# Technical Note 3: Highways

Project: Dobroyd Mill, Jackson Bridge / Hepworth,  
West Yorkshire

15 December 2017

This Technical Note has been written in response to the additional consultation response dated 7<sup>th</sup> December 2017 made by Kirklees Metropolitan Council (KMC) Highways Officers on planning application reference 2017 / 90620. The Council response is to the information submitted with our Technical Note 2 dated 20<sup>th</sup> November 2017 following a meeting with Officers earlier that month.

HYBRID APPLICATION PLAN

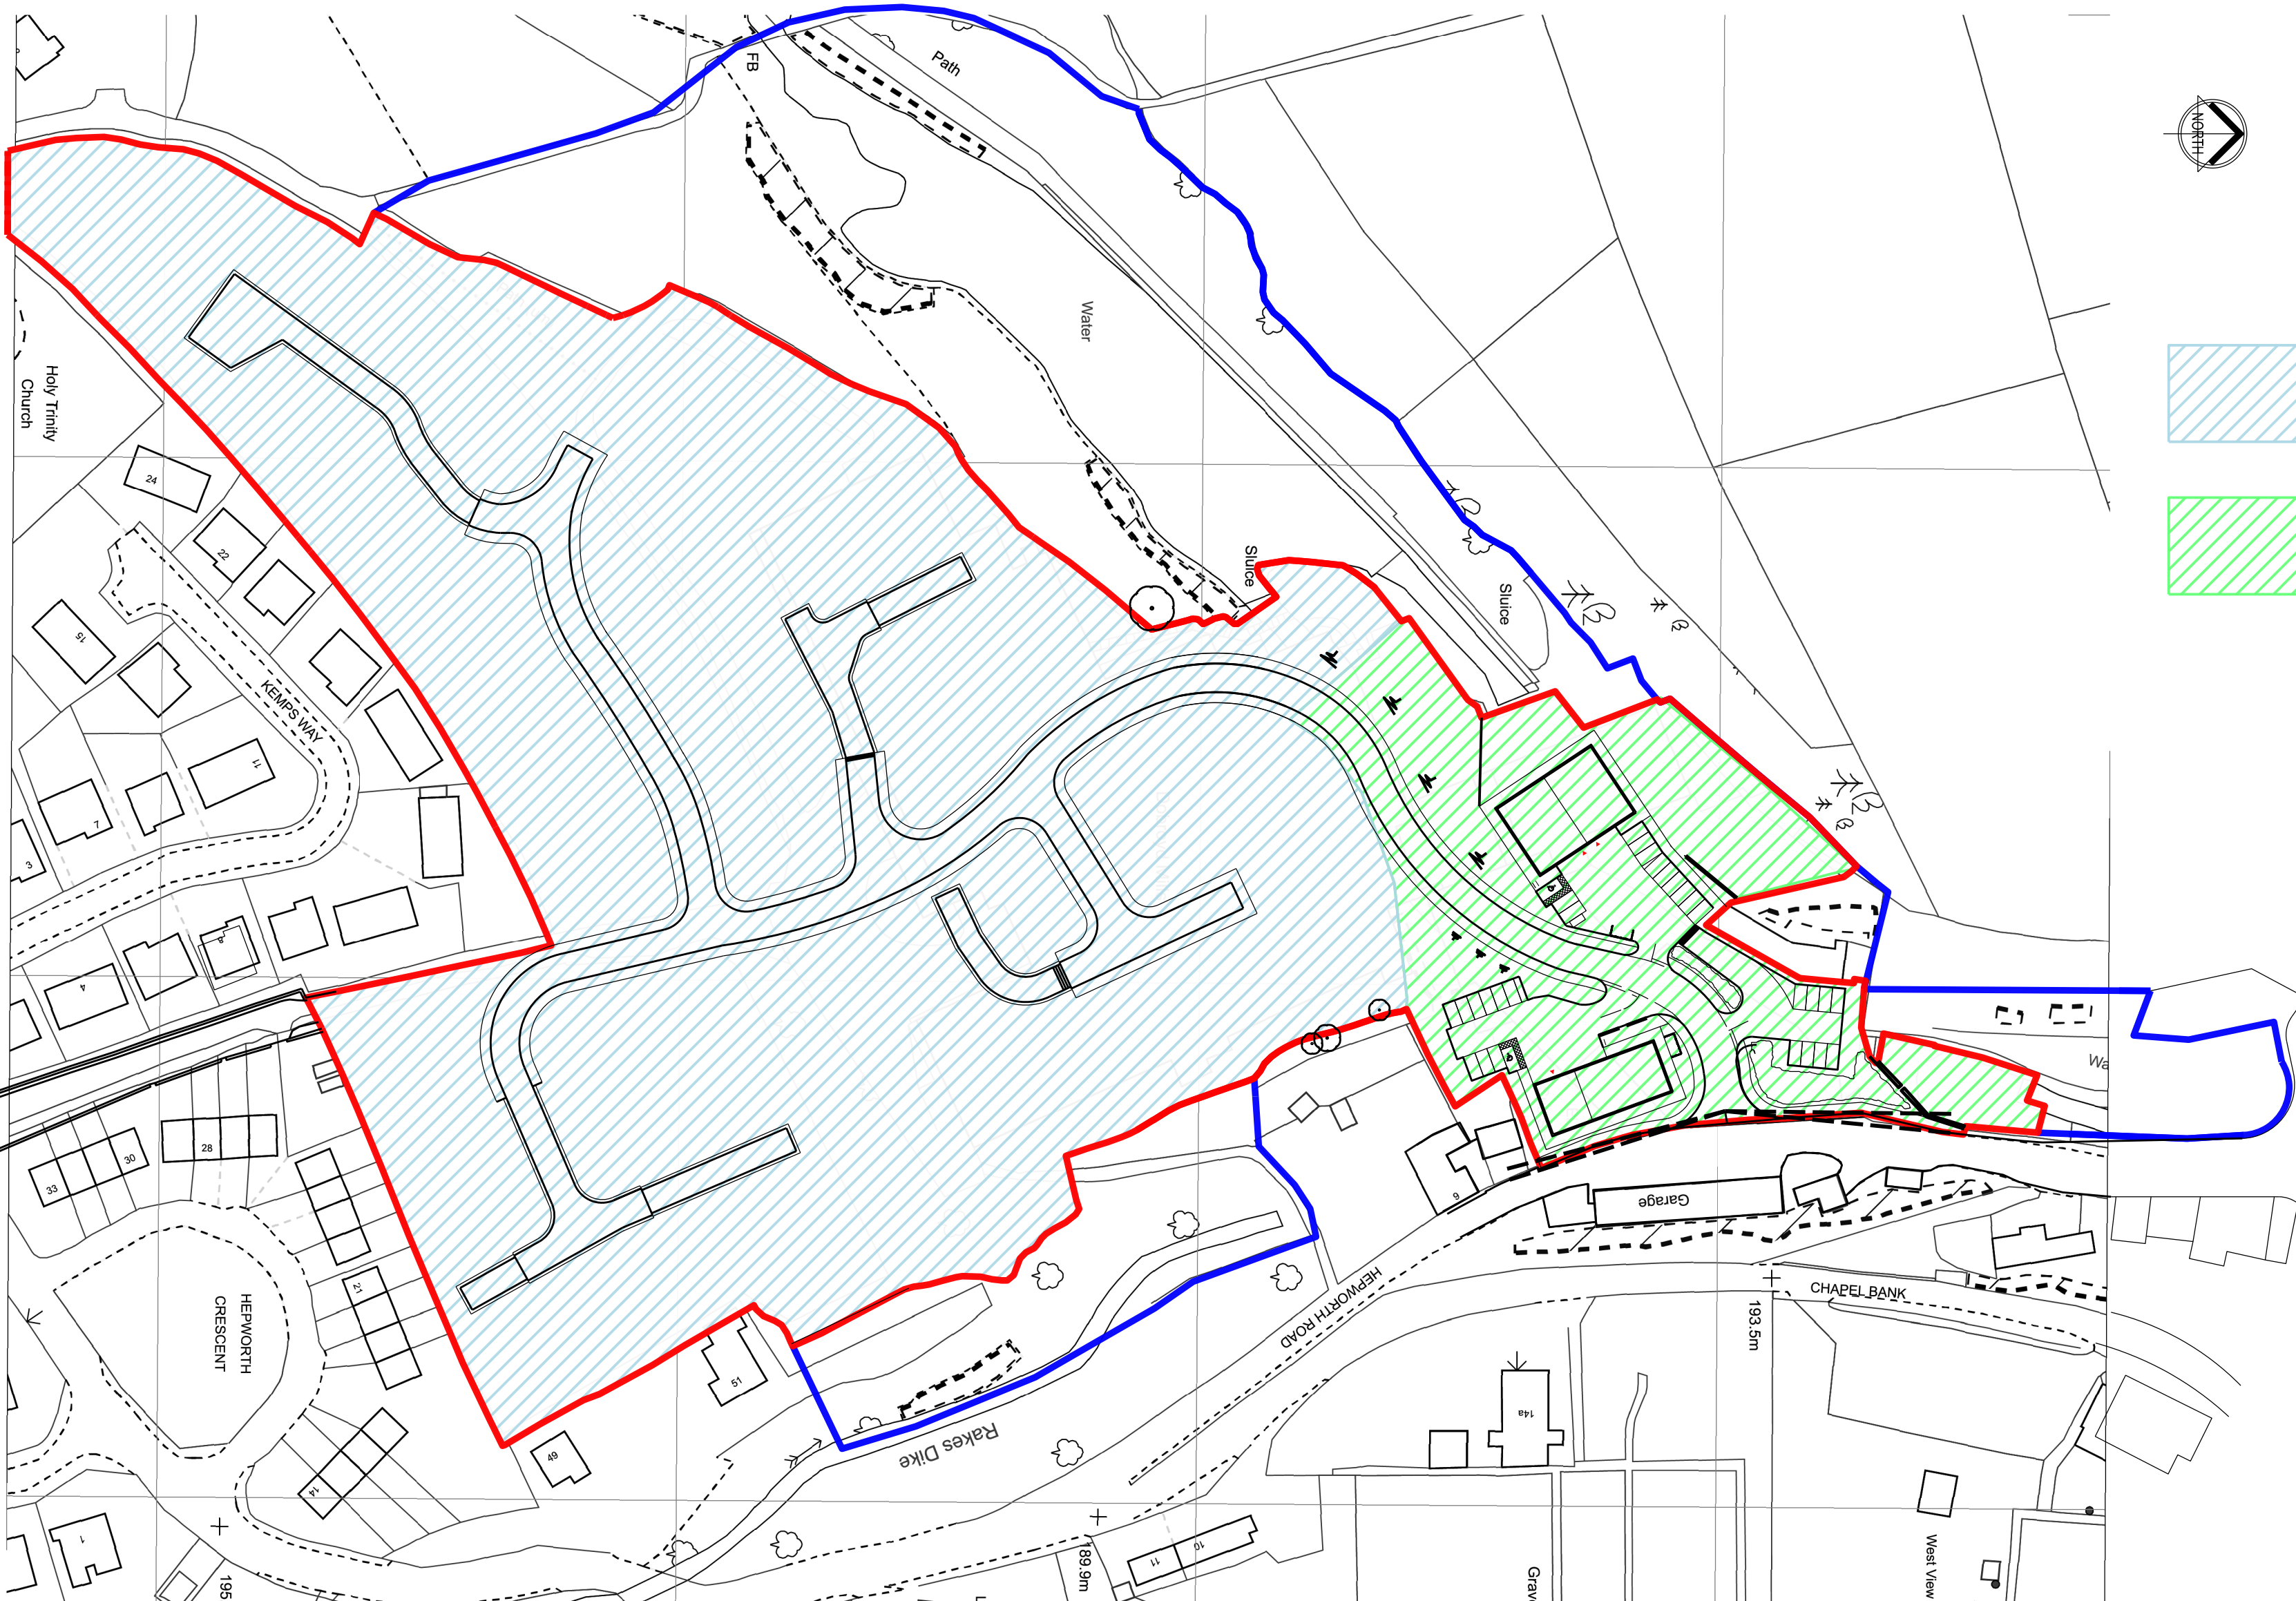
4, No cycle or motorcycle parking is shown to be provided. Secure cycle storage and motorcycle parking should be provided.

Cycle parking for the houses will be within their garages. Cycle parking for the apartments and the proposed employment use will be provided in accordance with Council guidance namely 1 space per apartment and 1 space per 300sqm of offices. The revised KPP drawings show these spaces.
